CITY OF ALBUQUERQUE

Re: **Hutton Snow Vista Modwash**
Snow Vista Blvd. SW & De Vargas Rd. SW
Traffic Circulation Layout
Engineer's Stamp 09-13-22 (M09-D012A)

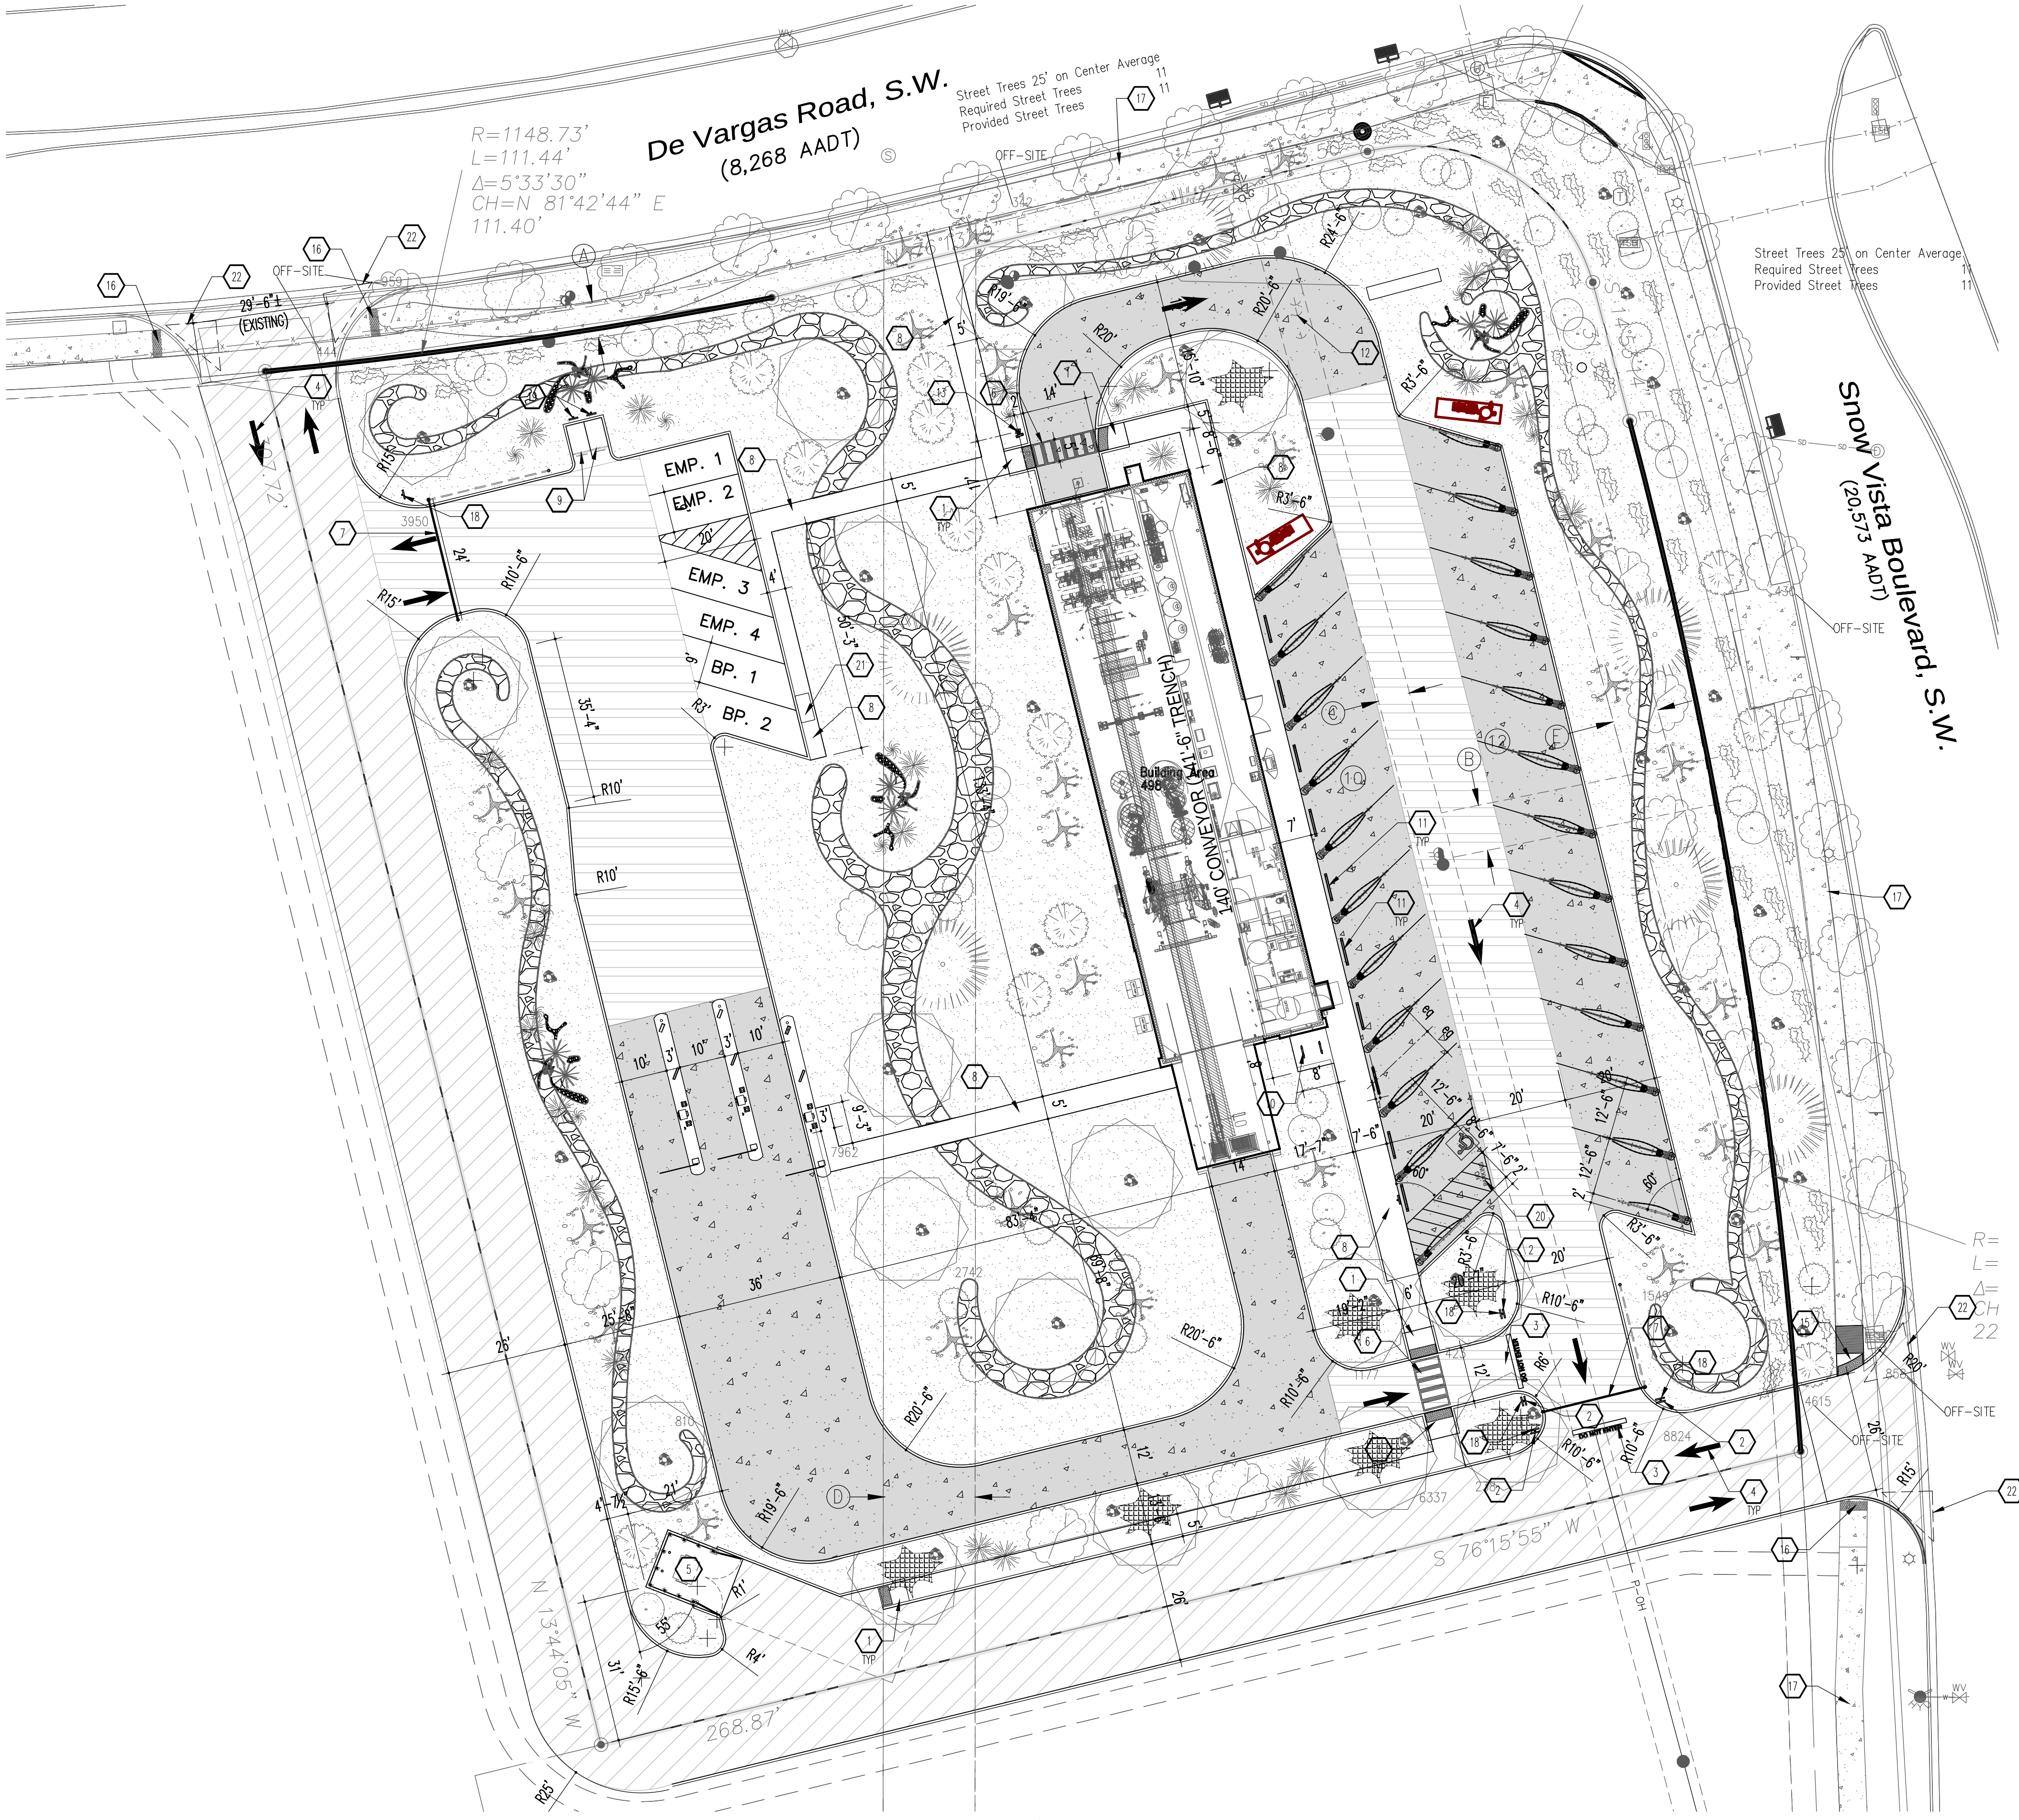
1. List the number of parking spaces required by the IDO as well as the proposed number of parking spaces including bicycle and motorcycle parking.
2. Identify the right of way width, medians, curb cuts, and street widths on Snow Vista Blvd. and De Vargas Rd.
3. Clarify existing property lines and proposed property lines.
4. Access Easement/ and or Approved plat action need to be provided.
5. Provide the width for the existing site driveway accesses.
6. Maximum access width for arterial, collector, and local streets are as follows:

7. Provide the angle for the angled parking spaces, and provide the correct dimensions by following Table 7.4.78 & 7.4.79 see attached Dimensions for angled parking.
8. The ADA accessible spaces must include an access aisle. Van accessible aisles should be 8ft wide; all others should be 5ft wide.
9. The ADA accessible parking sign must have the required language per 66-7-352.4C NMSA 1978 **"Violators Are Subject to a Fine and/or Towing."** Please call out detail and location of signs.
10. The ADA access aisles shall have the words **"NO PARKING"** in capital letters, each of which shall be at least one foot high and at least two inches wide, placed at the rear of

11. ADA curb ramps at the corner of Snow Vist and De Vargas Rd. must be updated to current standards and have truncated domes installed.
12. Motorcycle parking spaces shall be designated by its own conspicuously posted upright sign, either free-standing or wall mounted per the zoning code.

13. The pavement marking "MC" should be shown in the opposite direction for motorcycles entering the parking space.
14. All bicycle racks shall be designed according to the following guidelines:

18. Per the IDO, a 6 ft. wide ADA accessible pedestrian pathway is required from the public sidewalk to the building entrances. Please clearly show this pathway and provide details.

19. Per DPM, a 6 ft. wide ADA accessible pedestrian pathway is required from the ADA parking stall access aisles to the building entrances. Please clearly show this pathway and provide details.

20. ADA accessible pedestrian pathway should not be placed behind parking space or adjacent to a vehicular way. Vehicle and pedestrian/wheel chair conflicts should be avoided as much as possible.

23. Refuse vehicle maneuvering shall be contained on-site. The refuse vehicle shall not back into the public right of way. provide a copy of refuse approval.

24. Provide a copy of Fire Marshal Approval.
25. All one-way drives shall have "One Way" and "Do Not Enter" signage and pavement markings. Please show detail and location of posted signs and striping.

26. Please provide a sight distance exhibit
27. Show the clear sight triangle and add the following note to the plan: "Landscaping and signage will not interfere with clear sight requirements. Therefore, signs, walls, trees, and shrubbery between 3 and 8 feet tall (as measured from the gutter pan) will not be acceptable in the clear sight triangle."

28. Show the Clear Intersection Sight Distance and add the following note to the plan: "Landscaping and signage will not interfere with clear sight requirements. Therefore, signs, walls, trees, and shrubbery between 3 and 8 feet tall (as measured from the gutter pan) will not be acceptable in the clear sight triangle."
